Address: 58 Heaton Road Huddersfield

Application number: 2026/90666	
What is the application for?:	Rear landscaping and erection of retaining walls to the rear and side boundaries
Address of the site or building:	Sunnyside, 56, Heaton Road, Paddock, Huddersfield, HD1 4HZ
Postcode:	HD1 4HZ

EXISTING/PROPOSED WEST BOUNDARY WALL

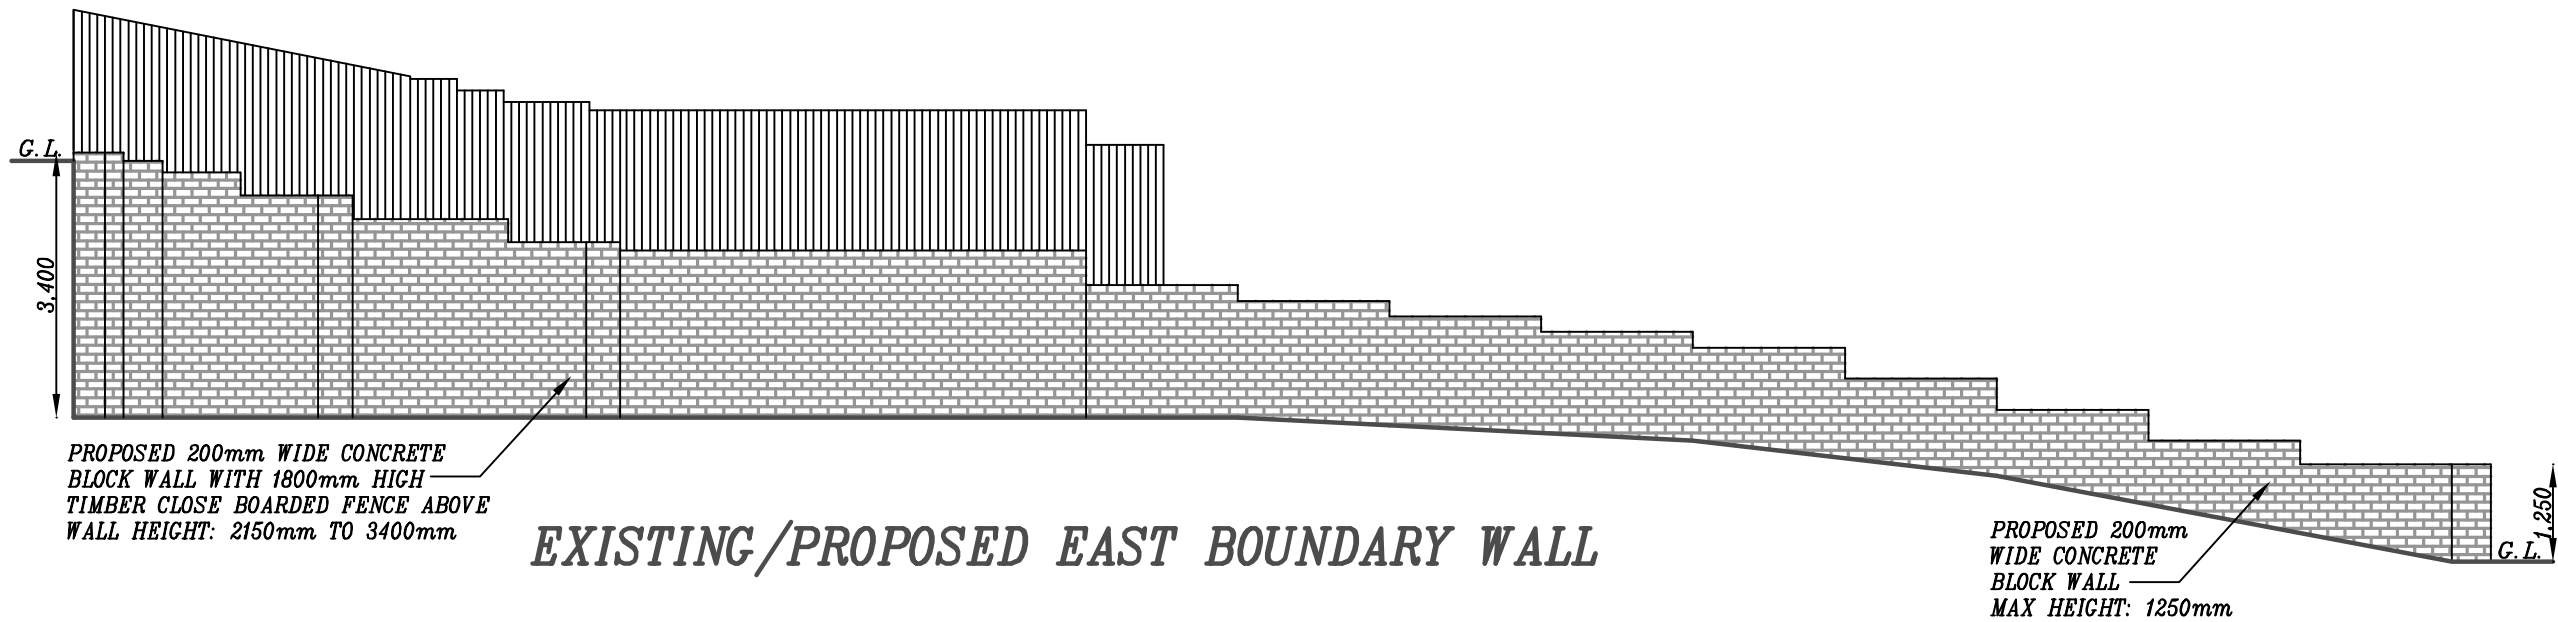
Type of comment: An objection	
Do you wish your comments to be published on the website anonymously?	No
<p>Our concerns relate to the wall between no 56 and our address. This wall (which is partly a retaining wall) was built by the applicant in place of a mature privet hedge, which was removed by the applicant of 56 Heaton Road.</p> <p>First, in relation to structural integrity: This wall has been built single-skinned, with poor quality, defective pointing, and we are concerned that the foundations are not sufficient as built, potentially compromising the structural integrity of our own property. Secondly, from a cosmetic perspective, the wall has been built from blocks and is unsightly. The applicant reassured us verbally that the wall would be rendered, however, this had not taken place. We would also like to point out that the fence erected on top of the retaining wall is substandard, for example, the fence posts appear to be too far apart which is likely to reduce its stability. In addition to this, the fence posts have been set into the ground on our property, rather than their own, as should be the case.</p> <p>Finally, we wish to draw your attention to the retrospective submitted plans (ref: 2026/62/90666), which only appears to consider retaining walls. The part of the boundary wall, which is not the retaining section, located to the side of the applicant's kitchen window, and connecting to the retaining part of the wall, does not appear to have been considered on these plans. However, where the unconsidered part of the wall now stands, was previously a 1.8m meter mature privet hedge which the applicant removed in order to build the wall. This wall is approx half the size of the now removed privet, and there has been no fence erected on top of this section of wall, meaning that once the applicant's extension is built, it will overlook the entirety of the front of our property, and part of the east side wall of our property which contains a window. This is unacceptable from a privacy perspective.</p>
